Submission No.	059
Organisation Name or Name of Submitter	Deirdre Vaughan (resident - 7 Fairfield Road, Glasnevin)

Letter Re: Metrolink Plan - Glasnevin to Griffith Park. Impact on 7 Fairfield Road, Glasnevin, Dublin 9.

DRAWING NUMBER: ML1-JAI-BOR-ROUT-XX-DR-Y-02857

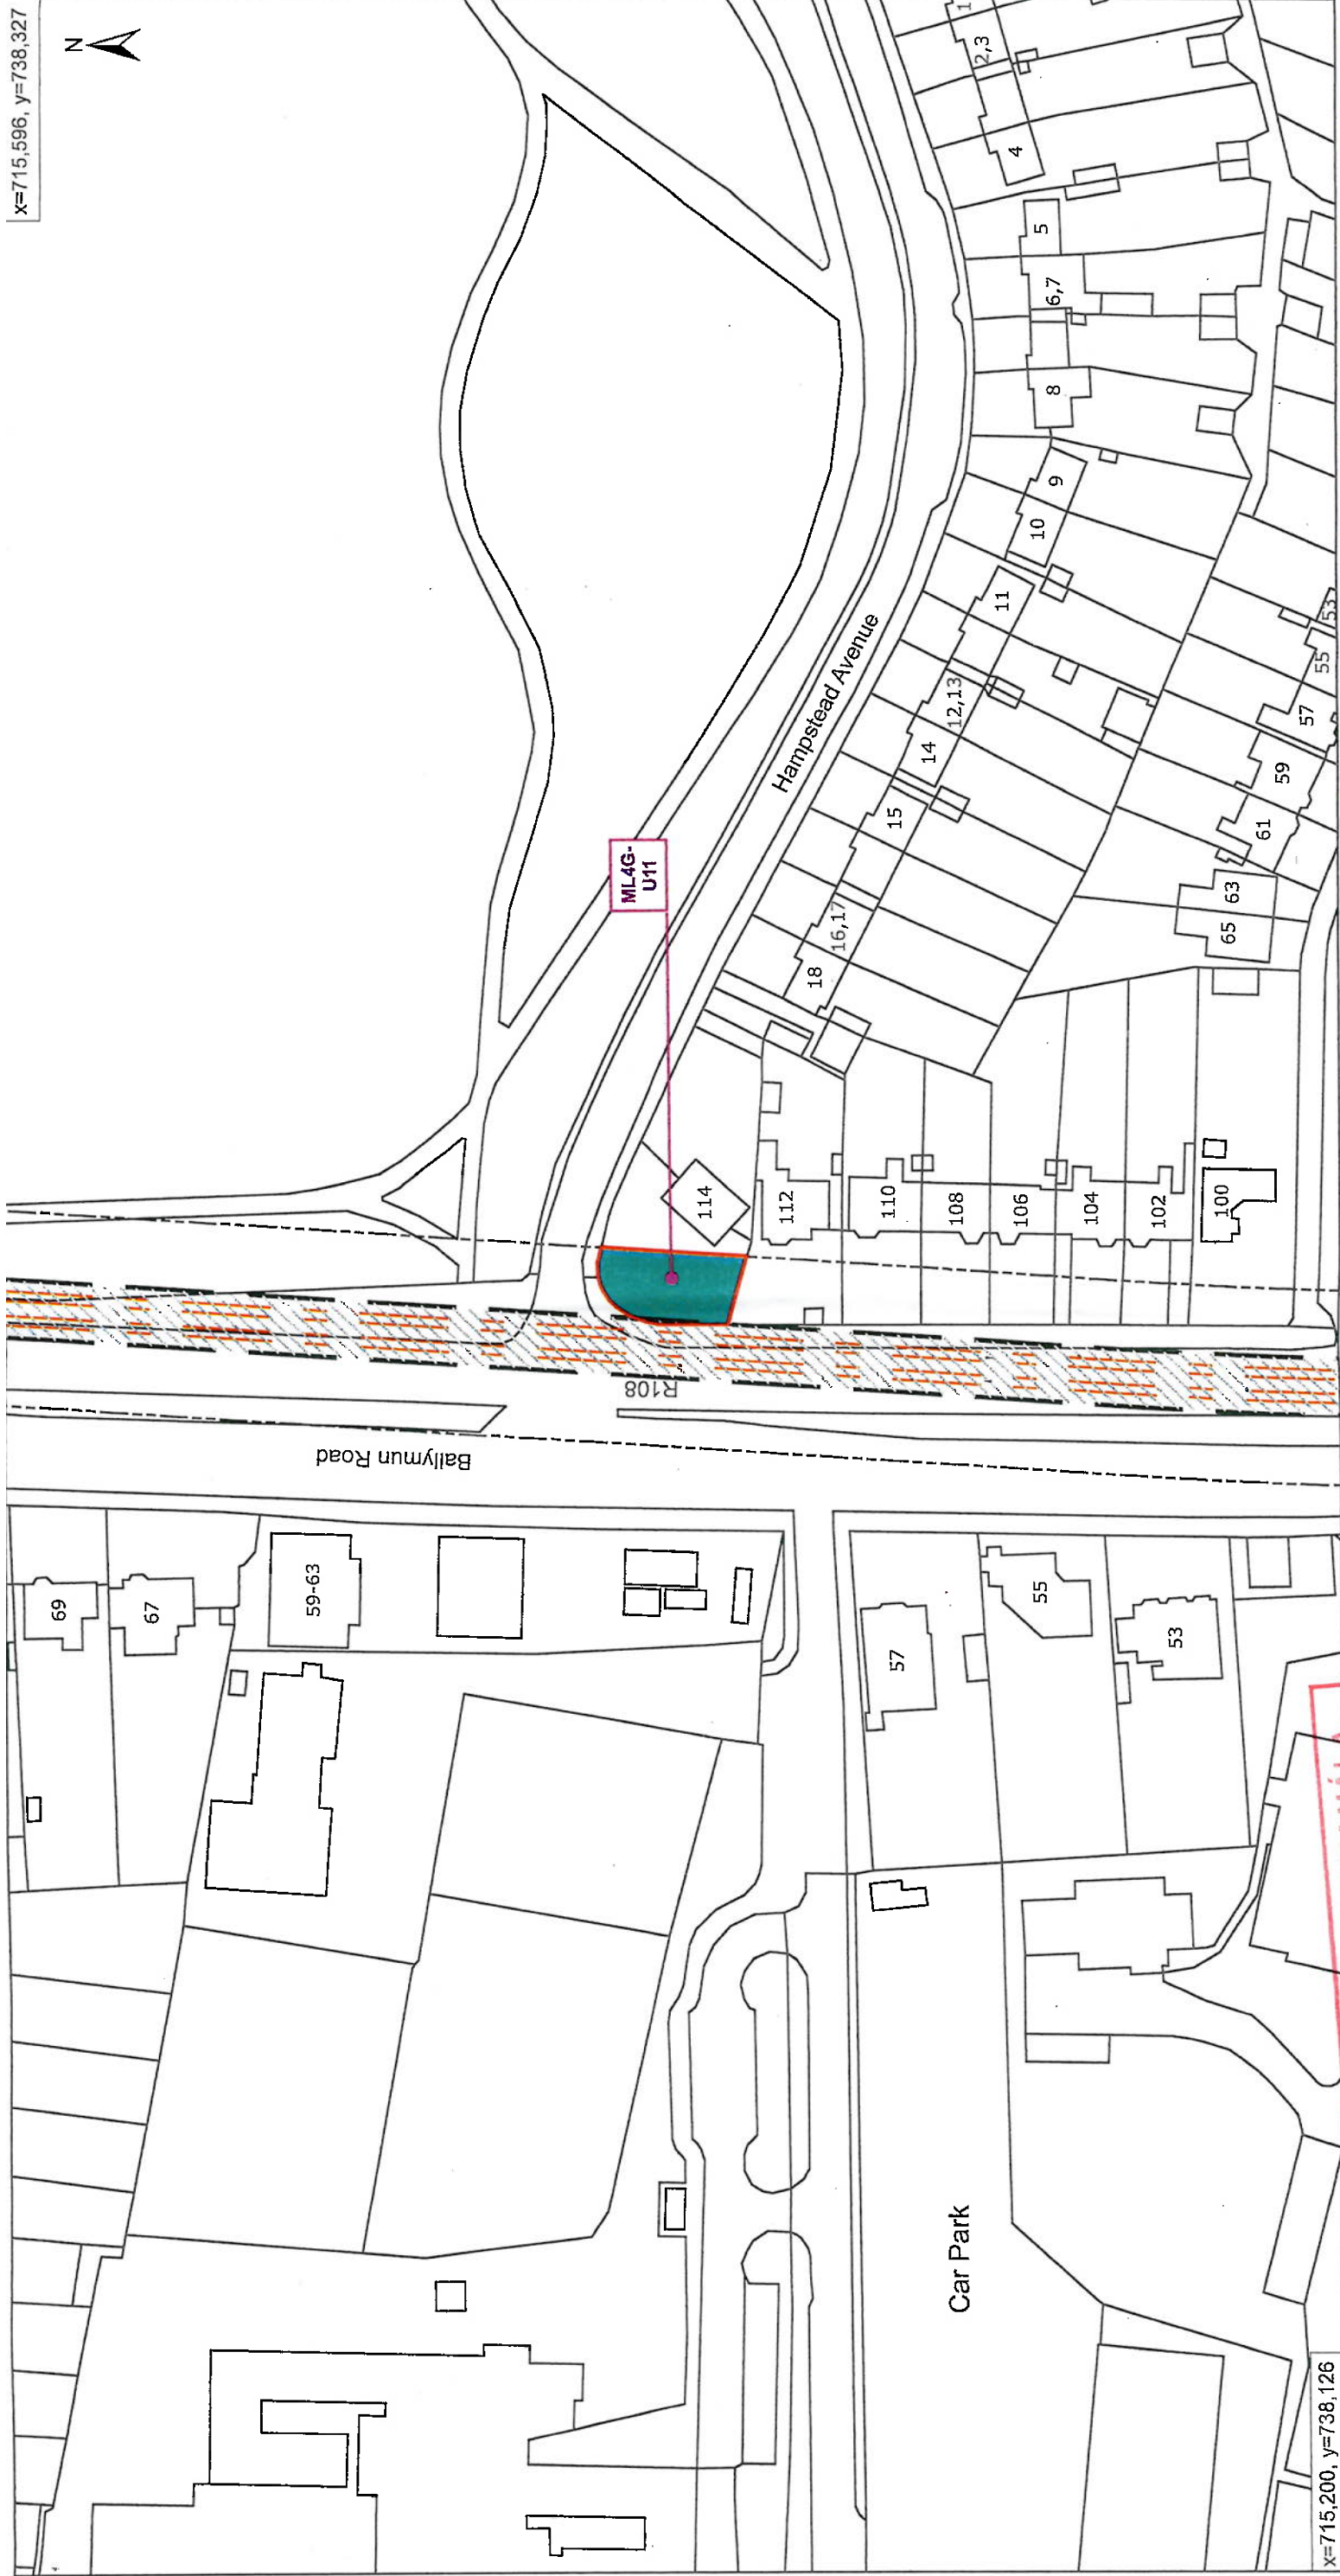
1	Letter	1	<p>I wish to object to the tunnel going underground under my property on the following grounds:</p> <ul style="list-style-type: none"> • Trespass into the subsoil under my property; • Concern regarding the depth below ground level of the tunnel; 	<p>Thank you for your submission and for sharing your observations with regards to the MetroLink project to which we have responded below.</p> <p>Substratum land take is shown on the Property Drawings submitted with the RO application and on Figure 21.1. Subject to a railway order being granted for the Scheme, TII will have the right to acquire the substratum land beneath this property for the purpose of constructing the Metrolink Scheme and as such can not be considered to be "trespassing" under the property concerned.</p> <p>TII acknowledge your concerns regarding the depth of the tunnel beneath your property. For the MetroLink project, the depth of tunnel will vary along the route but it is expected that the average depth will be approximately 24m from ground level to track level. In the vast majority of cases the subsoil can be acquired without affecting the above ground property. For 7 Fairfield Road the following data are shown on the individualised property details plan (please refer to Plan drawing no. ML1-JAI-BOR-ROUT_XX-DR-Y-03061, ML4L-U37):</p> <ul style="list-style-type: none"> • Ground level to crown of tunnel (m) - 11.8. • Ground level to track (m) - 18.5.
